EXHIBIT “G”

June 6, 2023

Subject: **Review of Revised Plans**
Proposed New Residence
6950 Southeast Maker Street
Mercer Island, Washington

PERMANENT SHORING PLAN

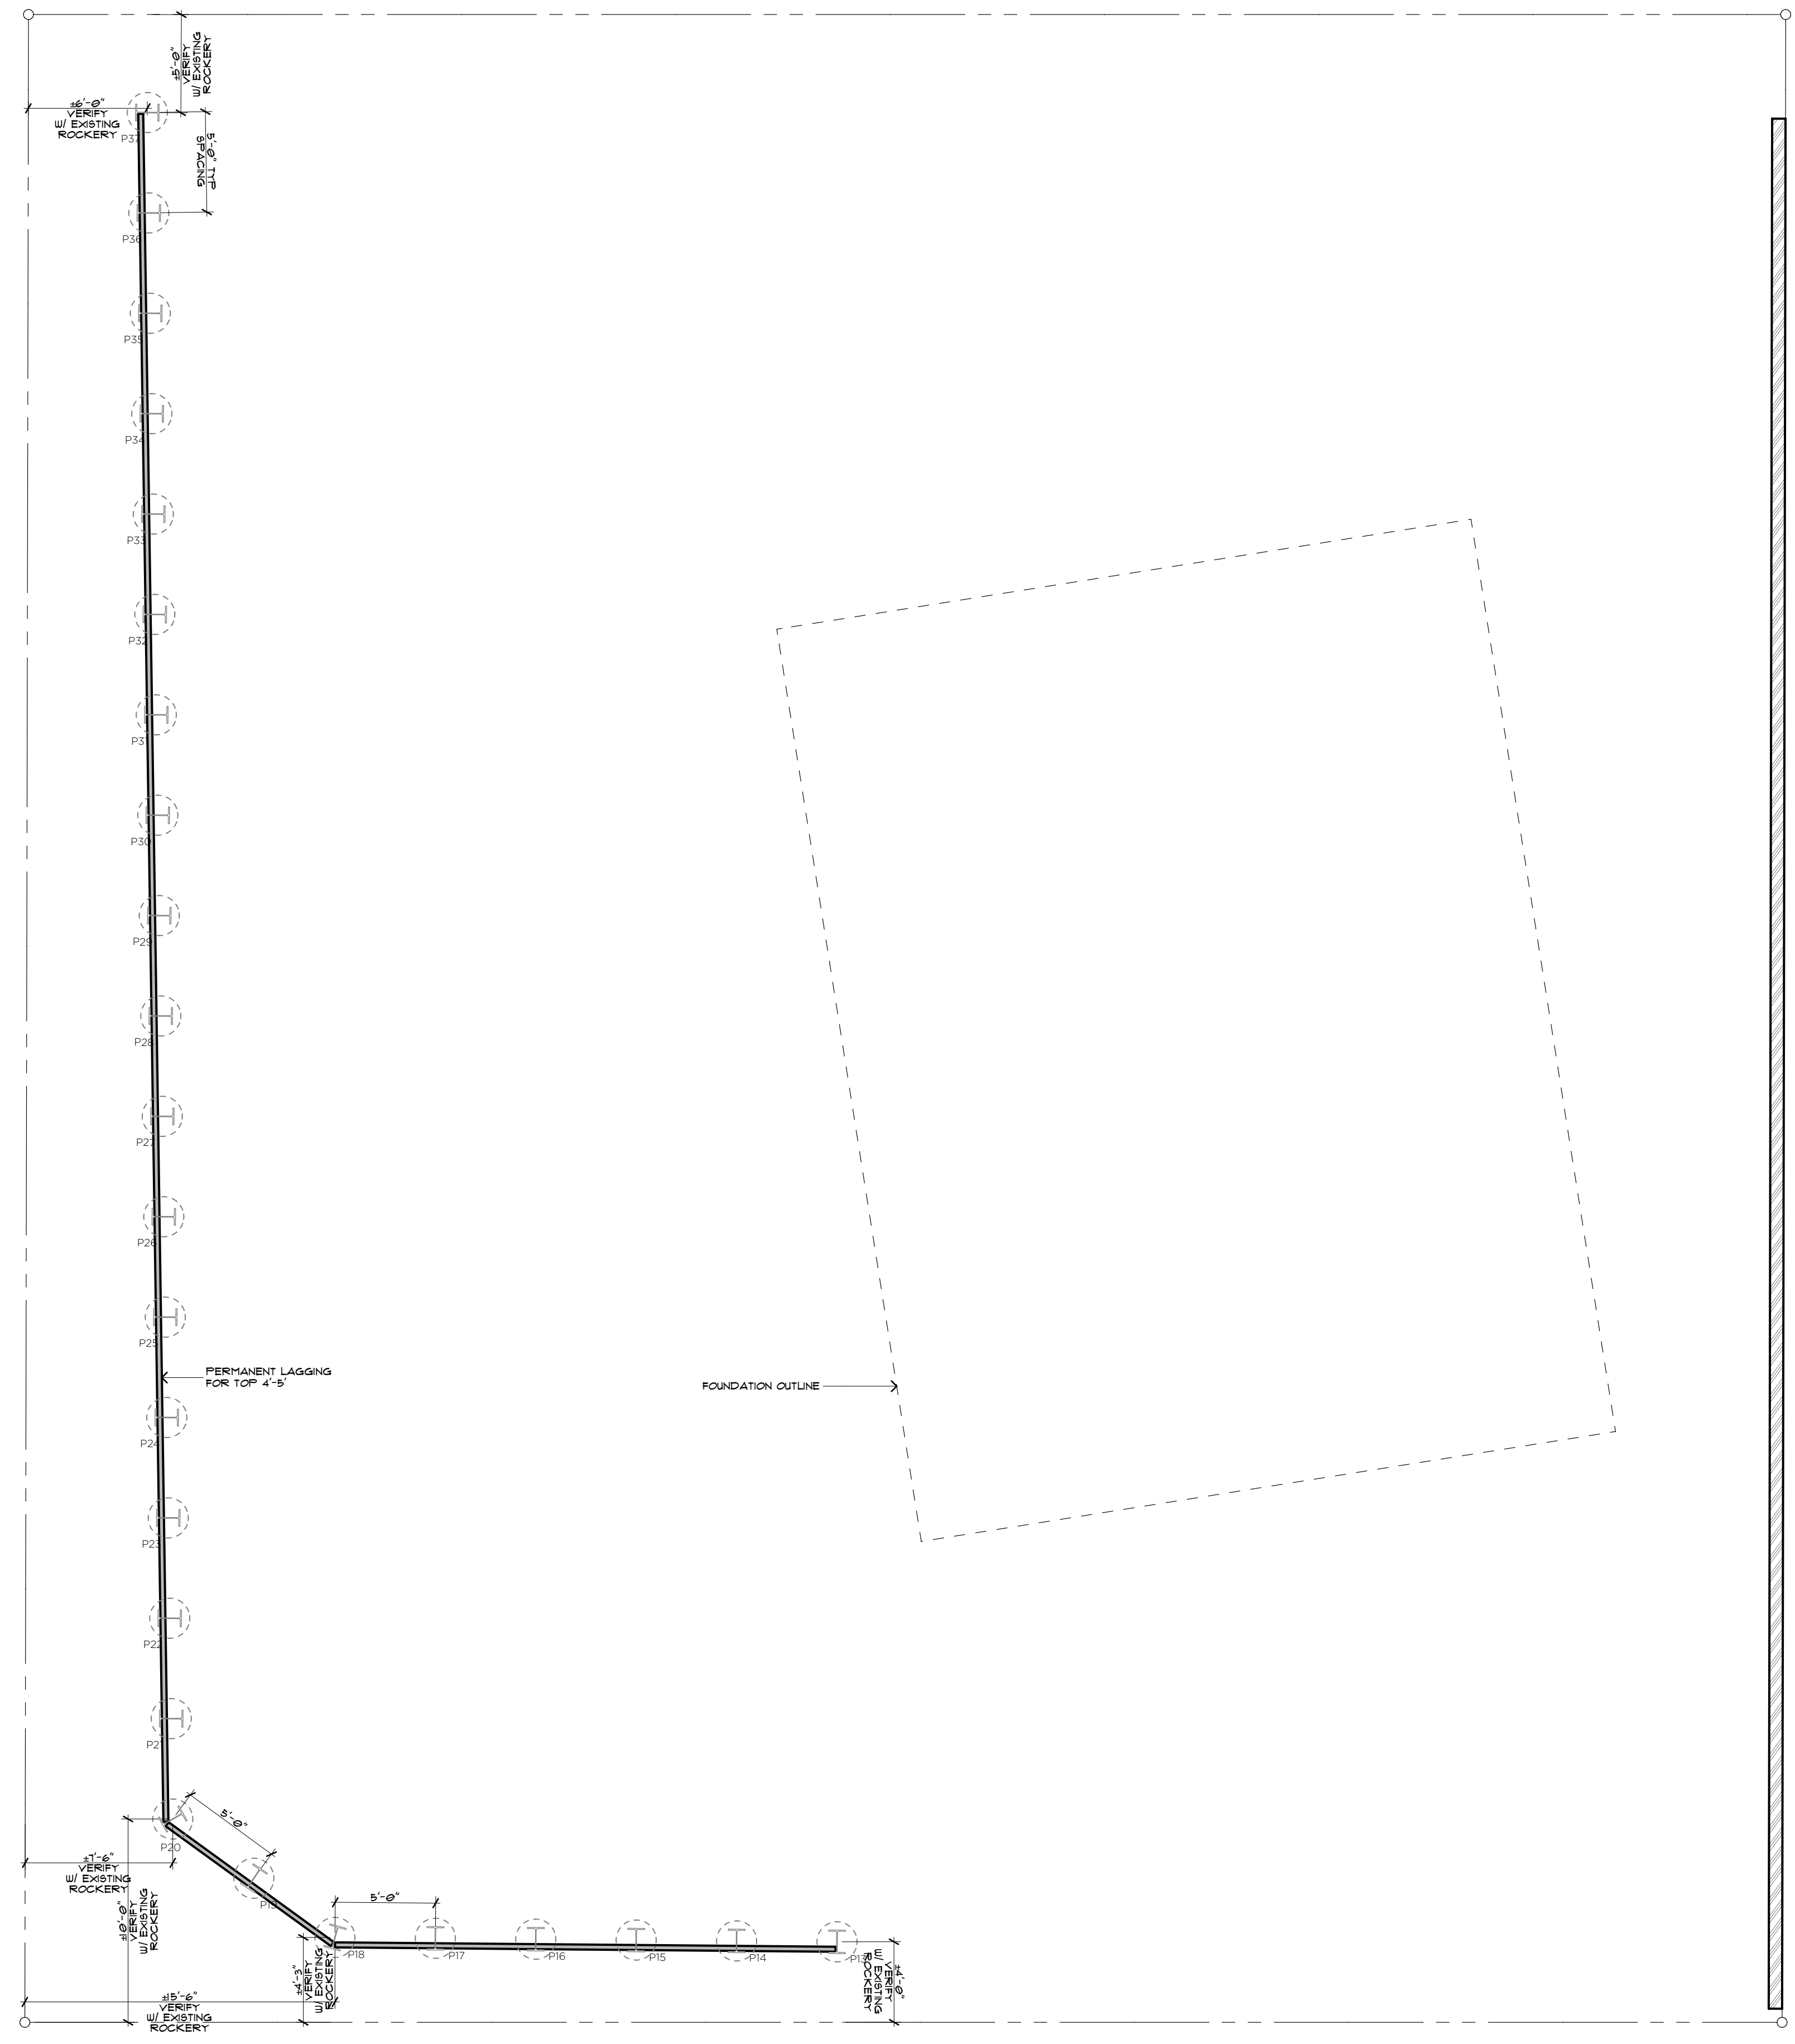
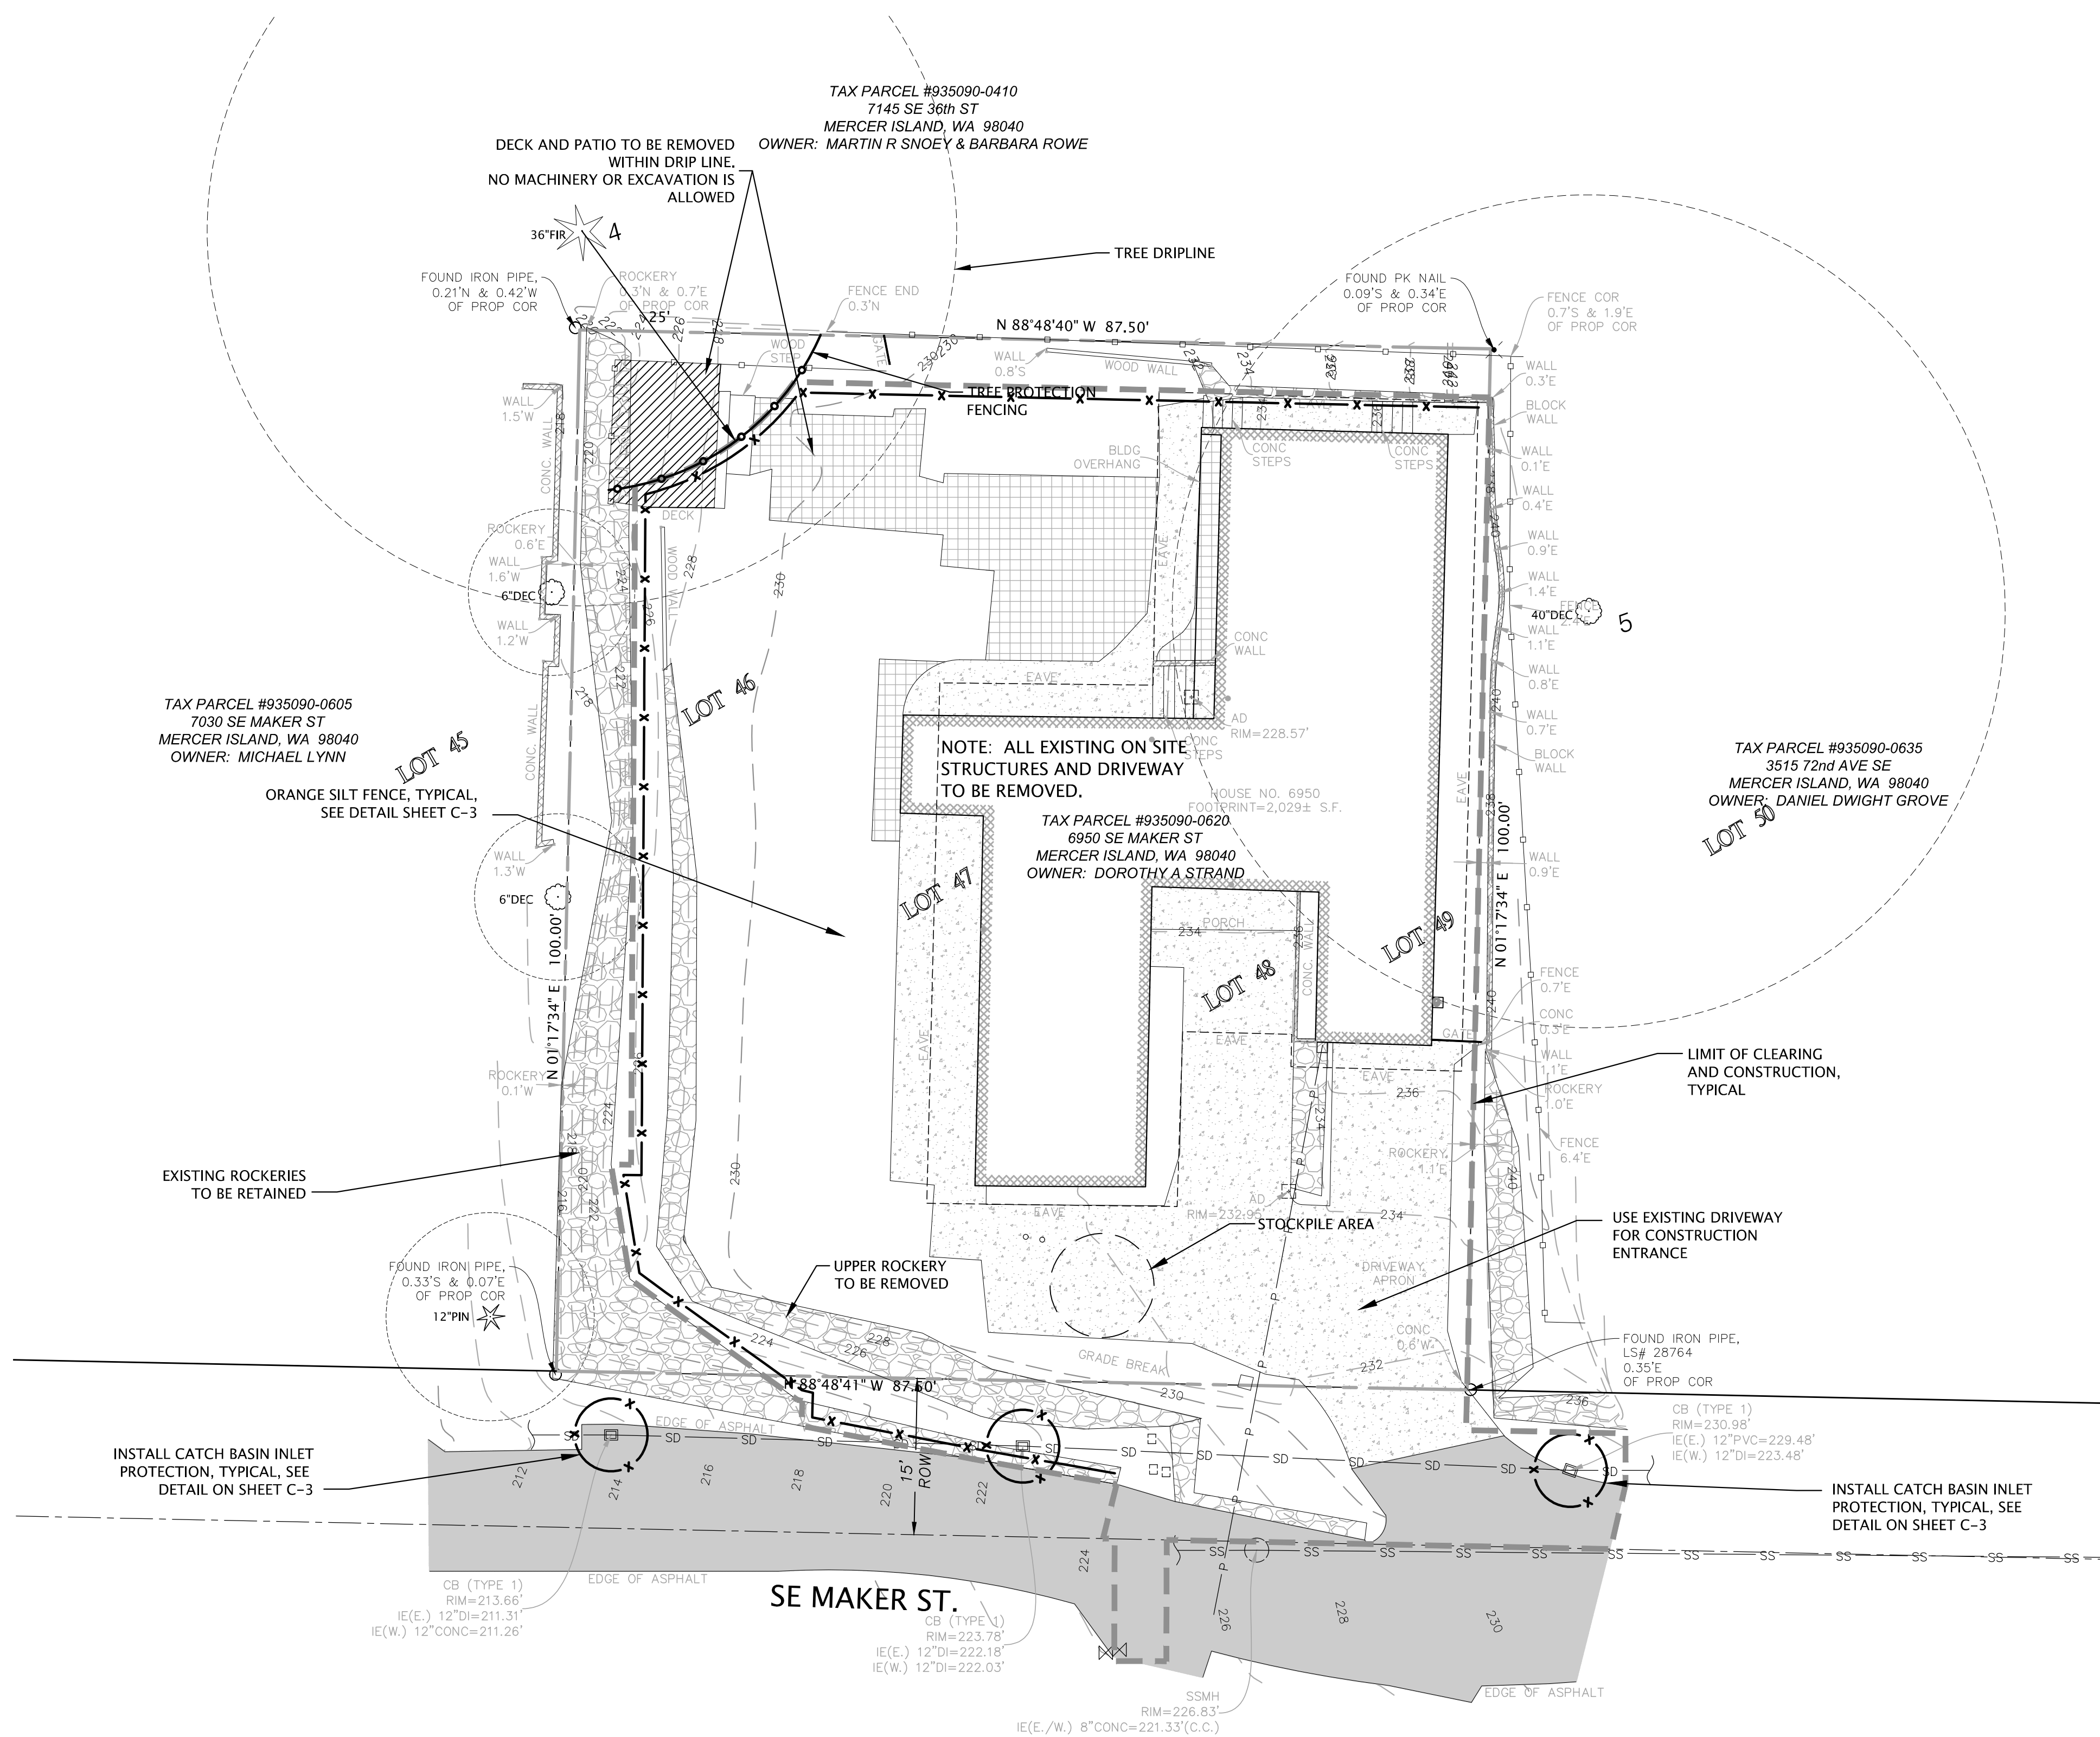
The shoring (SH) drawings correctly depict the partial removal of the existing western rockery, combined with the installation of closely-spaced soldier piles immediately behind the remaining lower portion of the rockery. The remaining lower approximately 5 feet of the rockery will no longer have to resist any lateral soil load, as this will be accomplished by the stabilization piles. This

JOB NO. 22038
SHEET
C-2

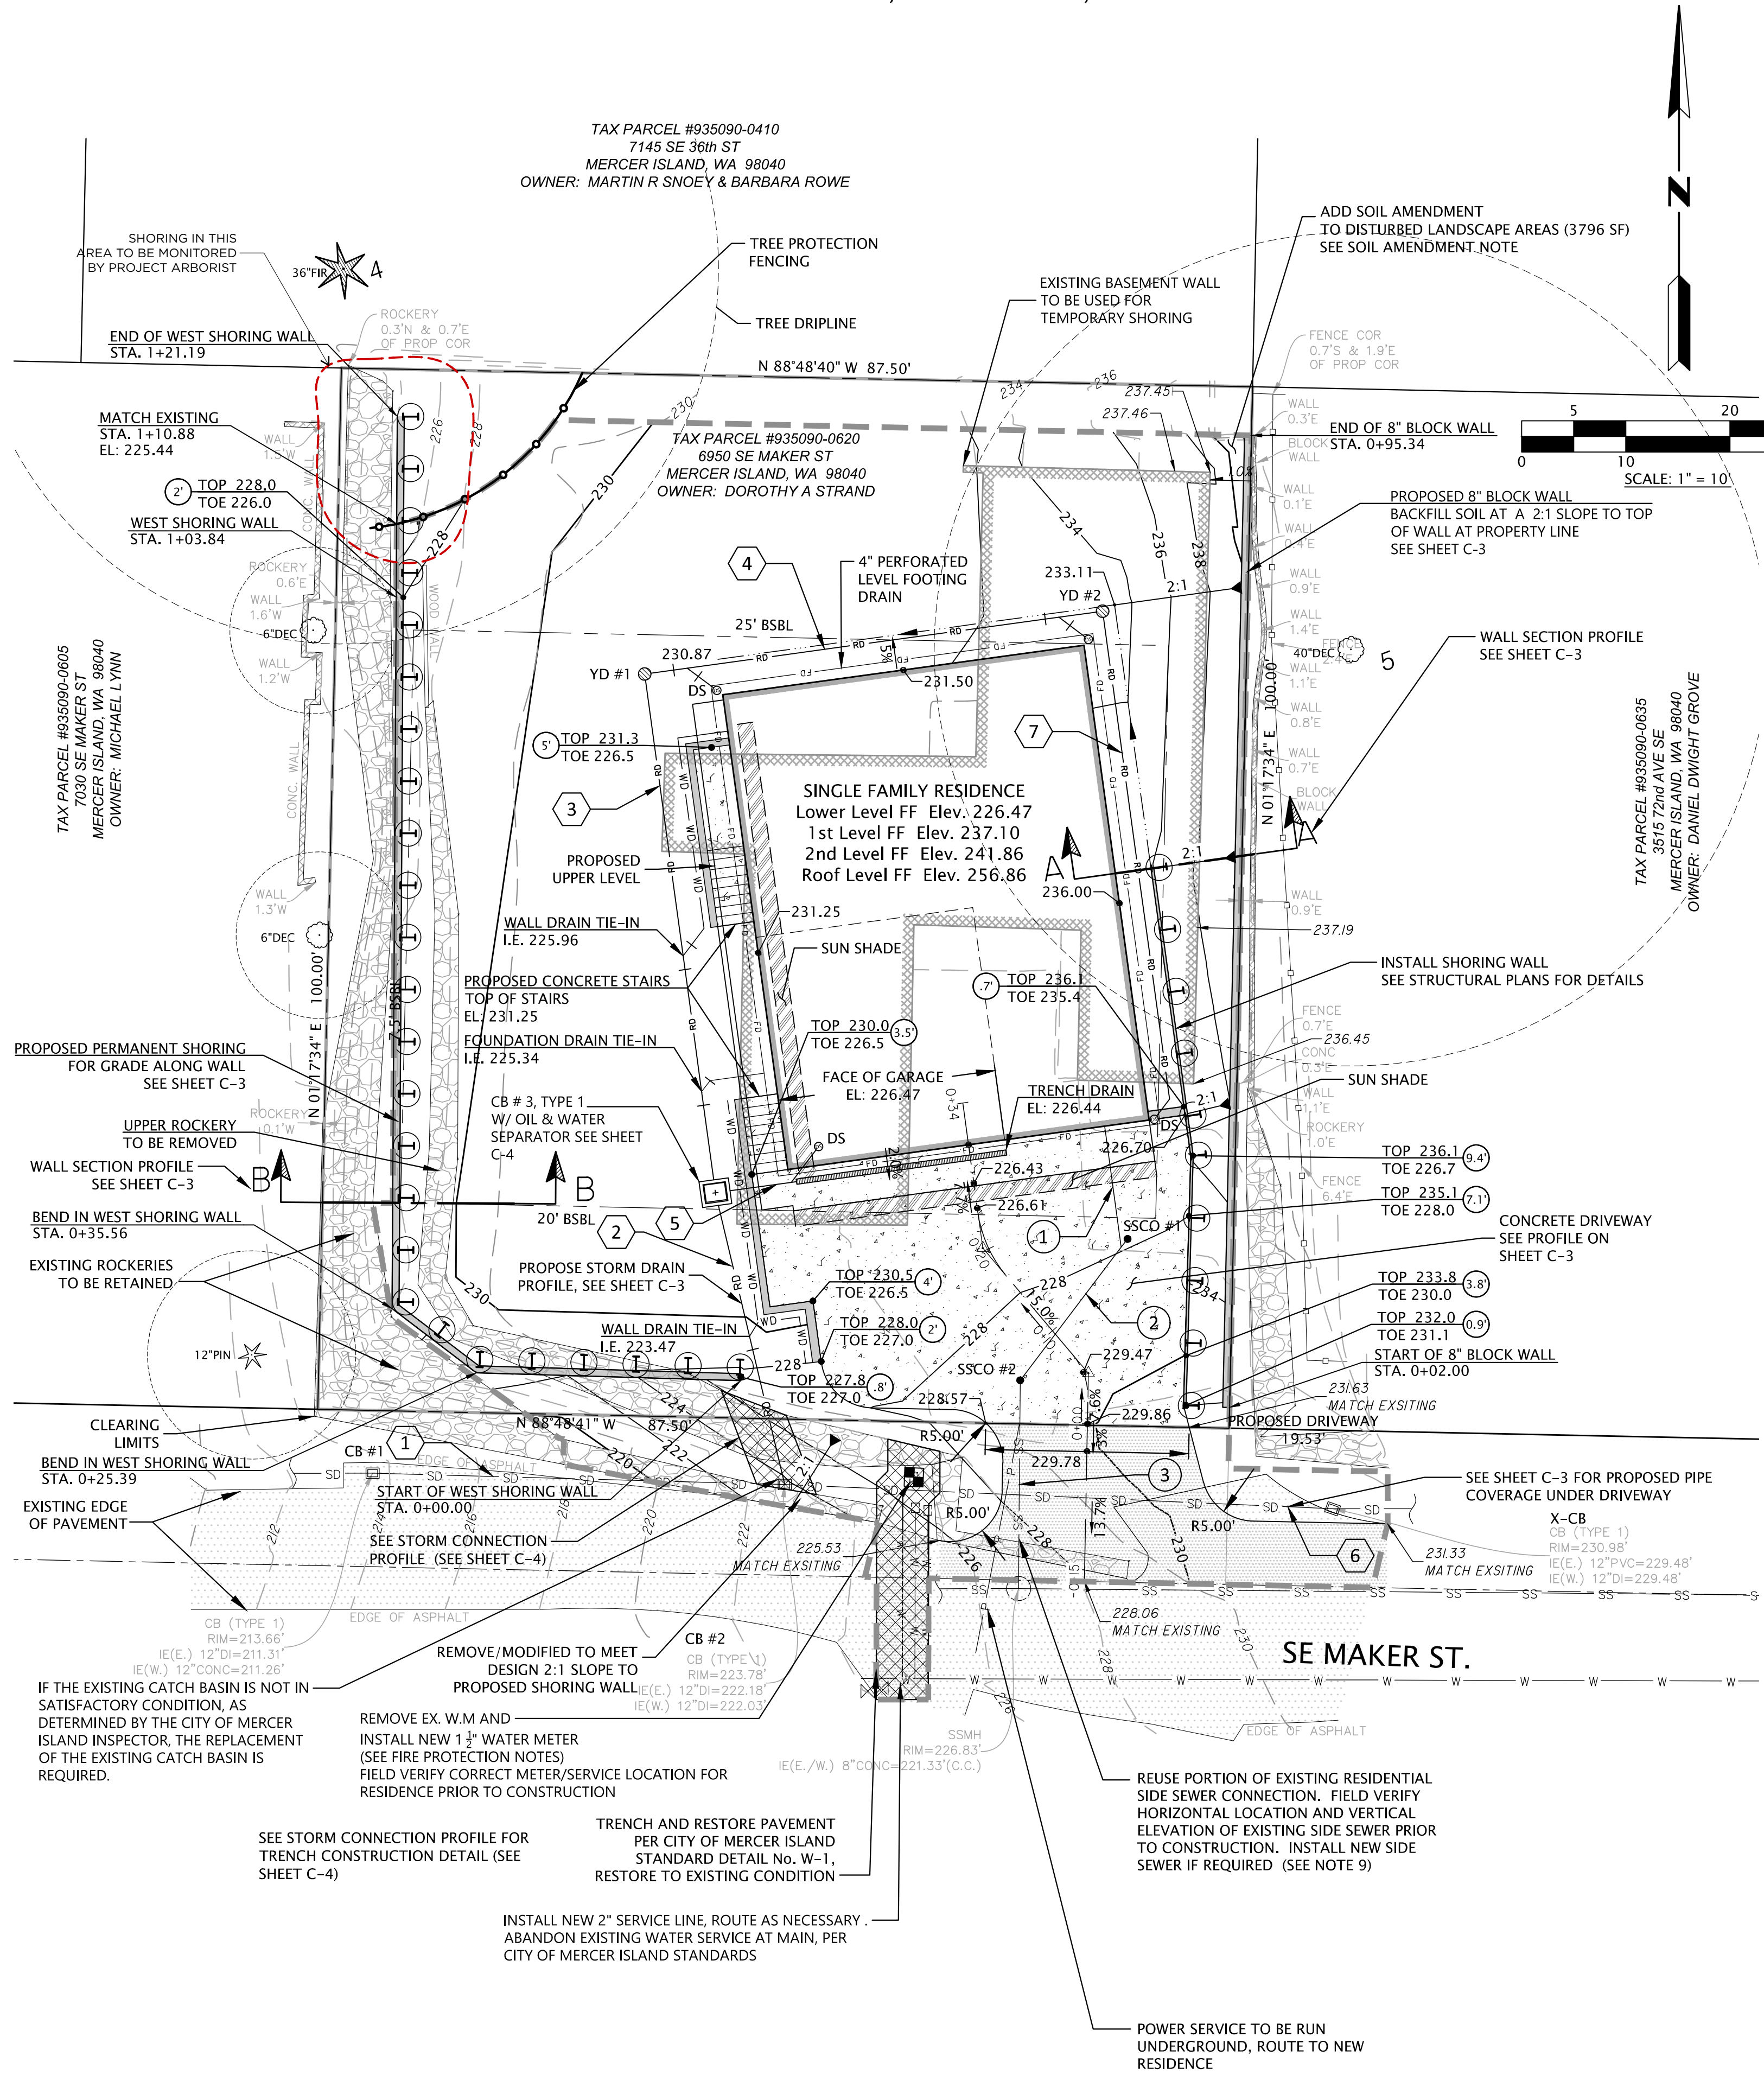
The Site Plan and sections on SH1, as well as sheets C-2 and C-3, properly illustrate the fill berm and modular block wall to be constructed as protection against a potential failure of the eastern neighbor's modular block wall.
